STEWART BUILDING (L20-D57). GRADING AND DRAINING PLAN FOR RE: BUILDING AND SO #19 PERMIT APPROVALS. ENGINEER'S STAMP DATE JUNE 25, 1997.

RE: Drainage Plan for Stewart Building (L20-D57)

The review comments made by Carlos Montoya in his letter dated June 11, 1997 for the above referenced project have been addressed as follows:

RE: Drainage Plan for Stewart Building (L20-D57) Received May 27, 1997

VACATION AND PLAT OF
LOT 10-A, BLOCK 38
SKYLINE HEIGHTS SUBDIVISION

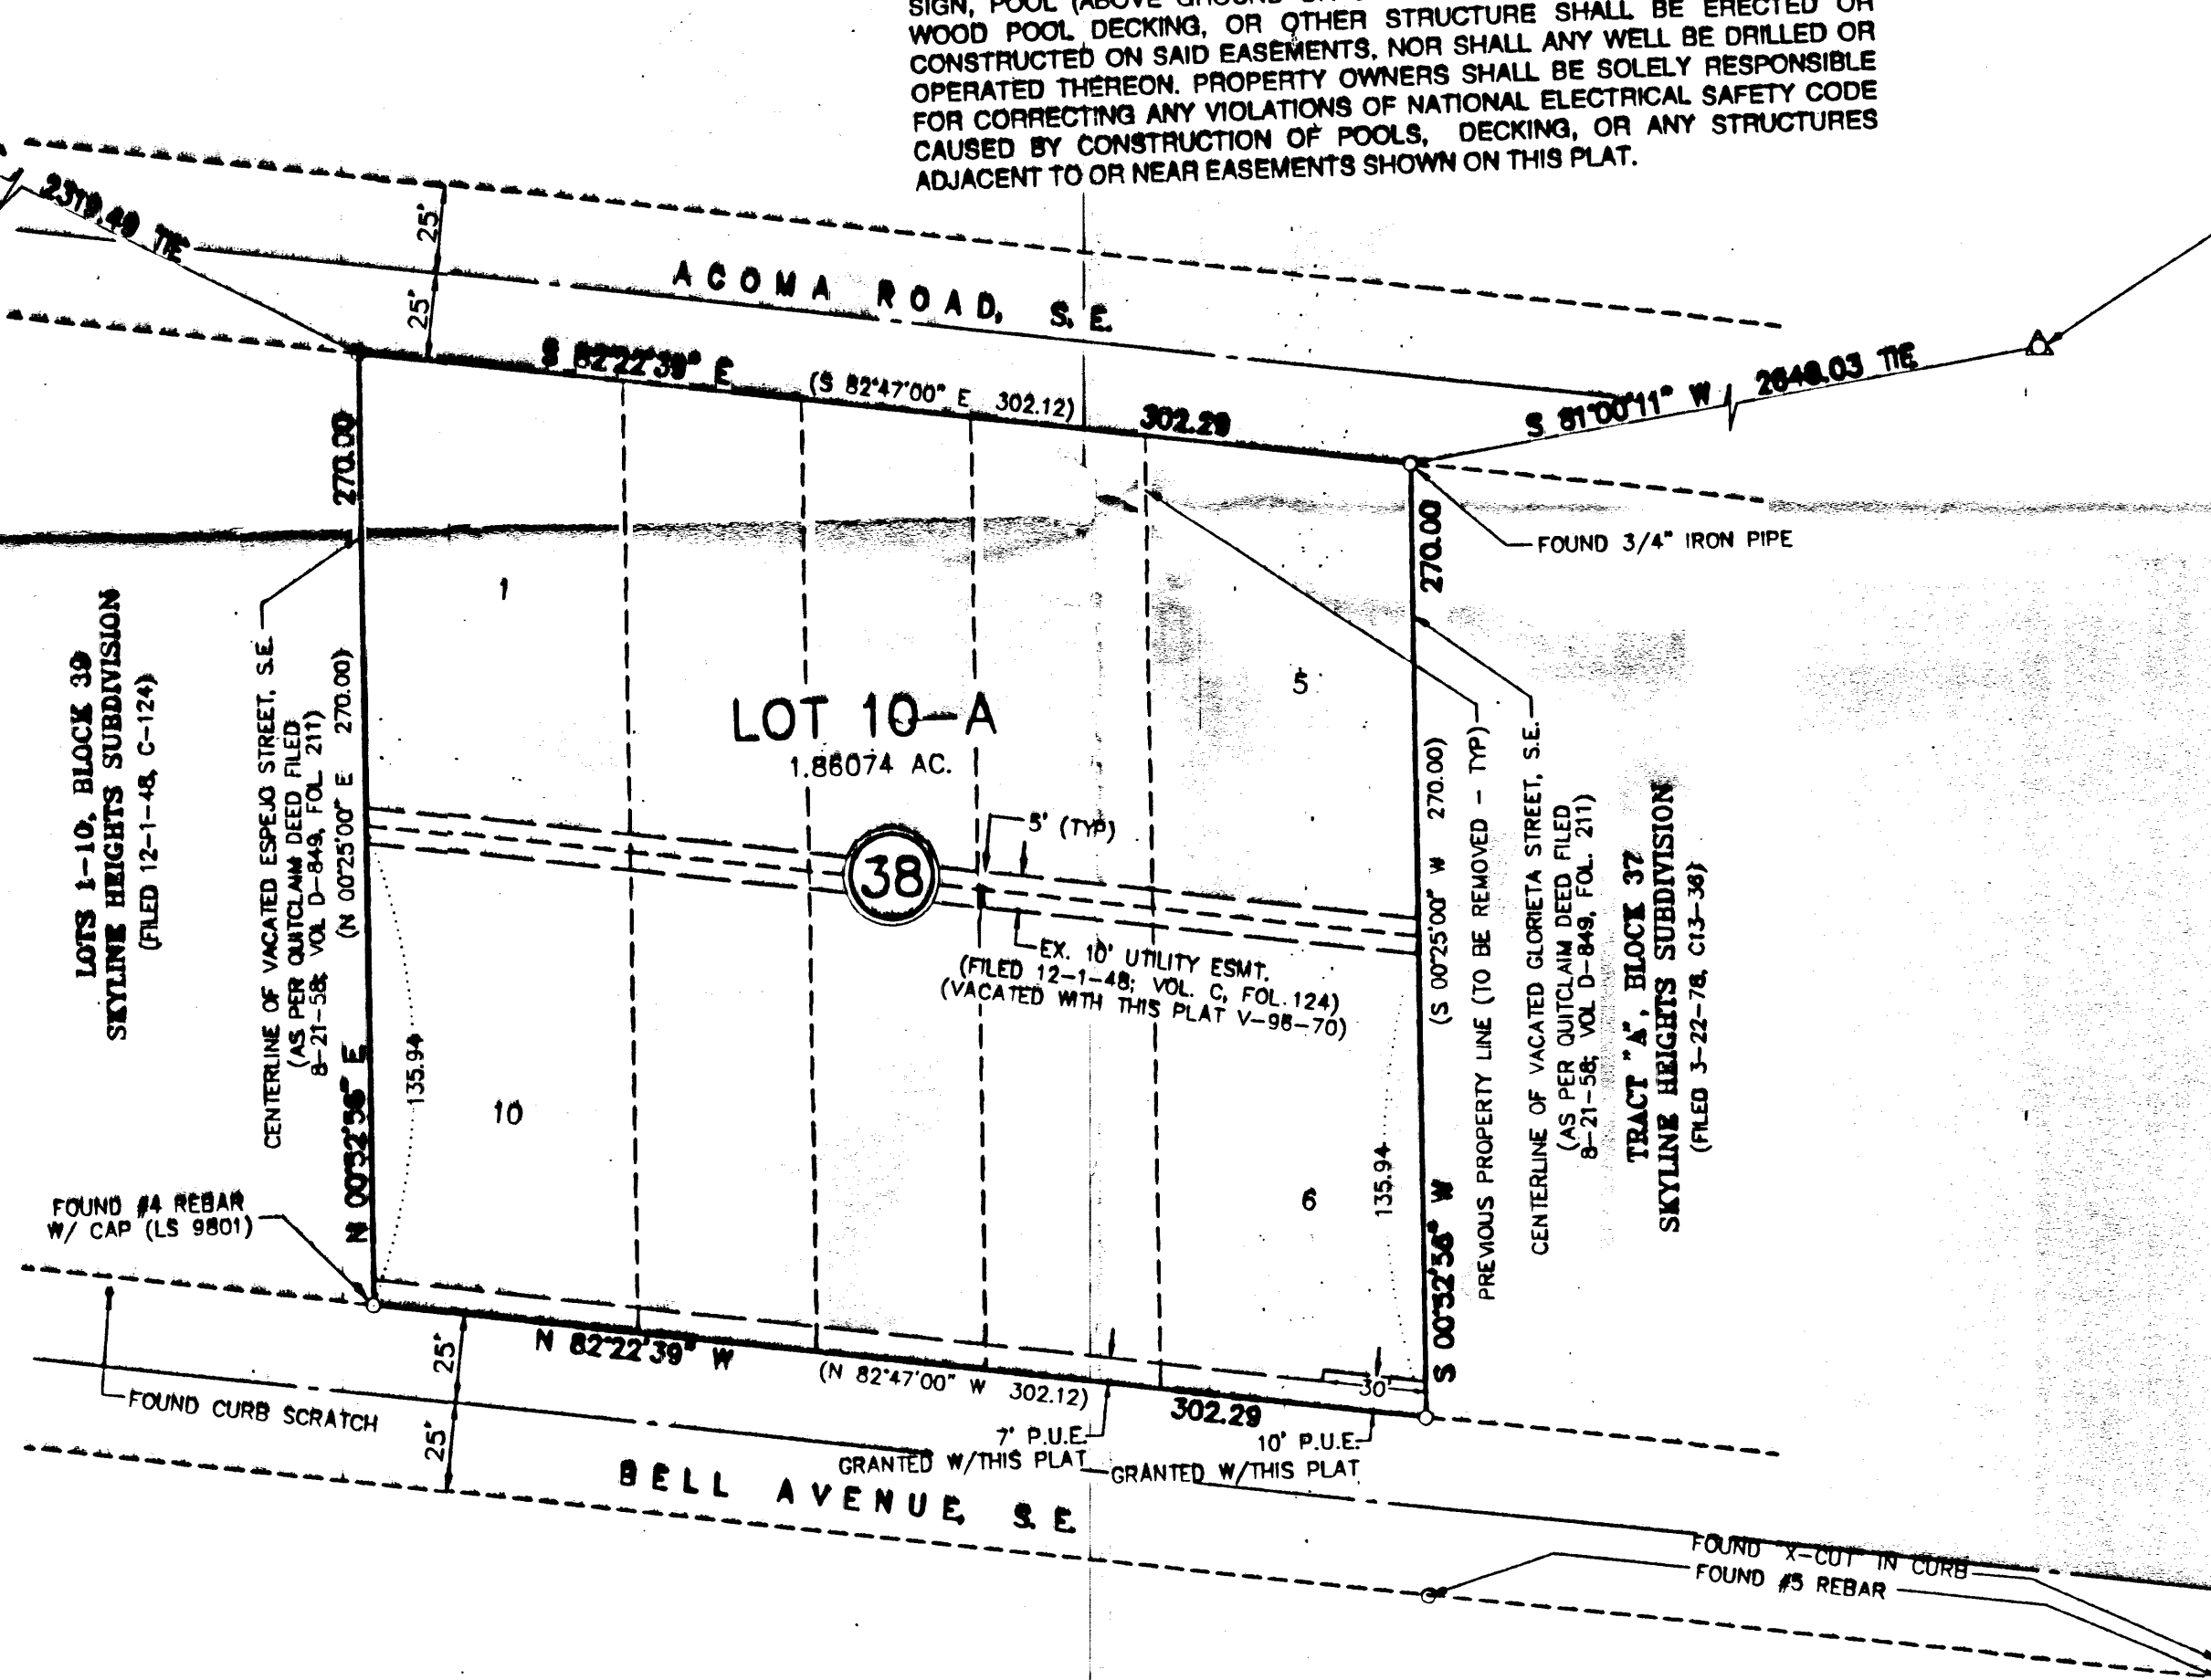
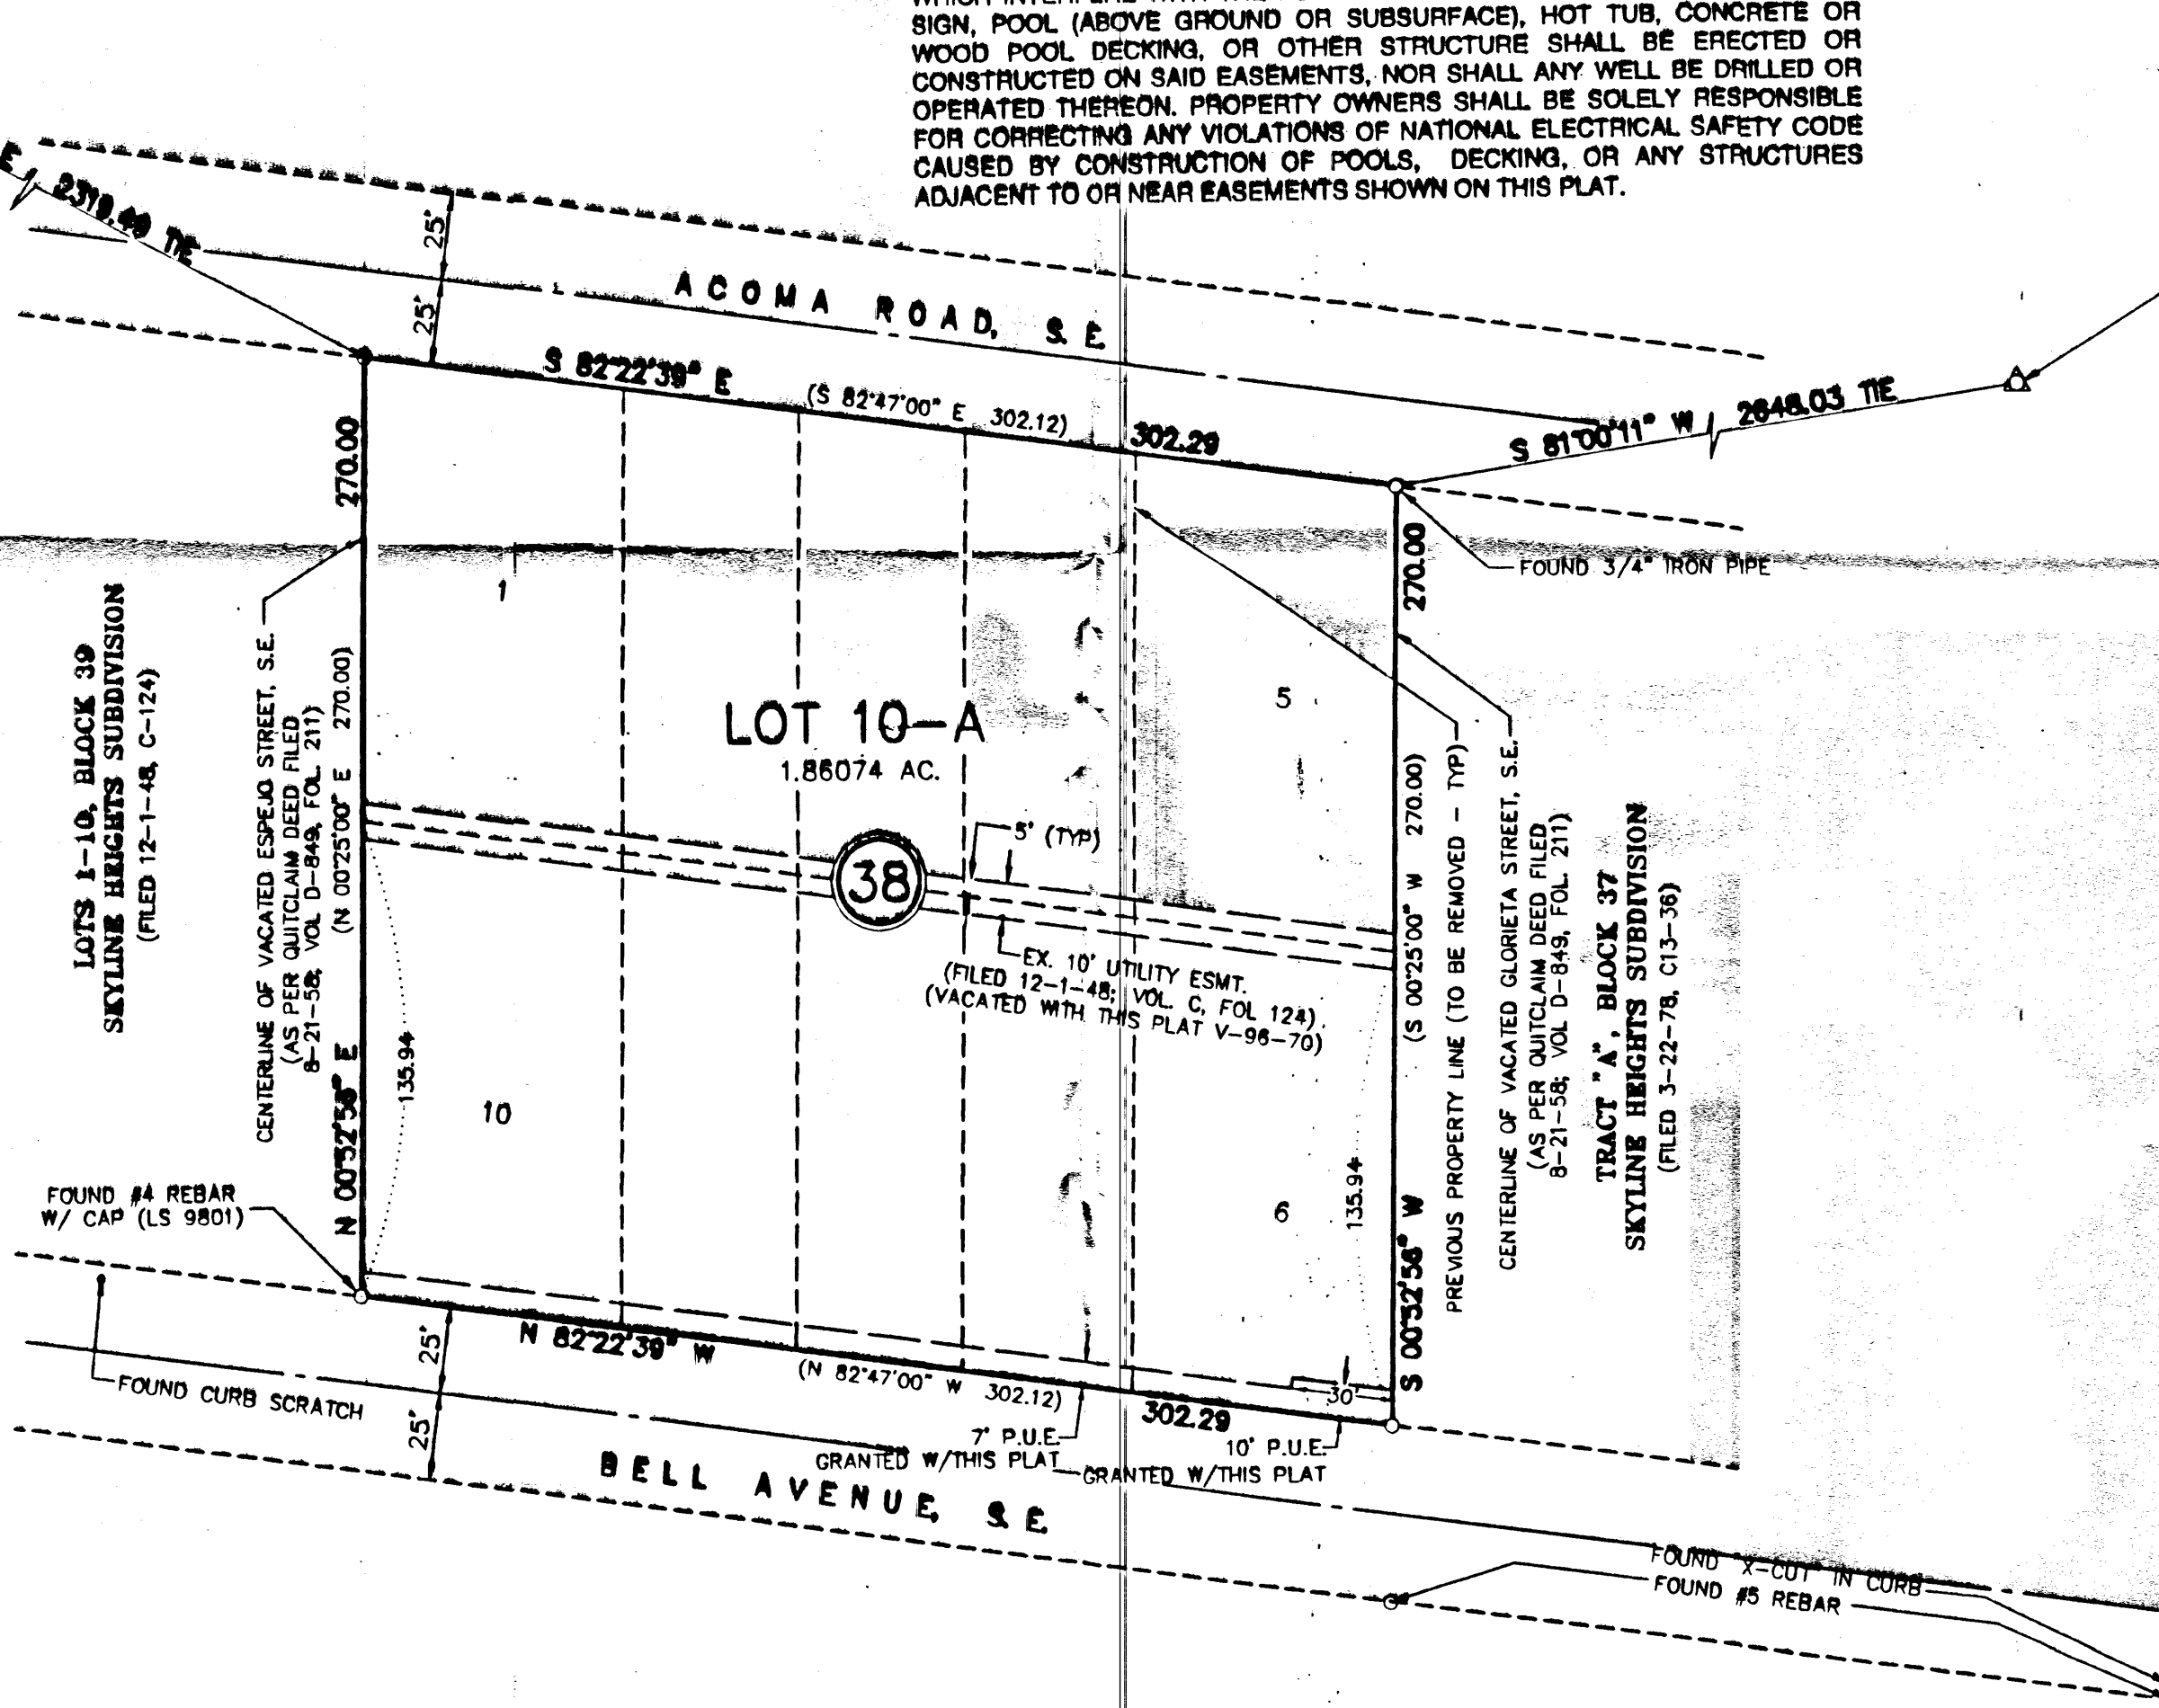
- 1. The construction of the sidewalk culvert in the City Right-of-Way will need to be processed through an SO #19.
- 2. Please submit the new plat with your next submittal. Otherwise, I need an agreement that allows cross lot drainage for the 10 lots.
- 3. When a property is developed you cannot discharge on to the downstream private property. If you do discharge on to the private property you need concurrence from the downstream owner.
- 4. Please give a detail of the proposed swales.
- 5. Please show the roof drains for the building and the mobile home.
- 6. Show proposed spot elevations for the proposed asphalt parking lot and 24 foot asphalt entrance.

- 1. The SO#19 for the sidewalk culvert will be processed at the time of construction.
- 2. A copy of the plat is attached. It has not been recorded at this time due to an issue between PNM and Mr. Stewart. As soon as this is resolved, Kym Dicome will sign the plat and it will be recorded. The attached FAX indicates Community Sciences Corporation latest attempts to bring this to closure. Please proceed with this drainage review assuming the plat will be recorded by the July deadline.
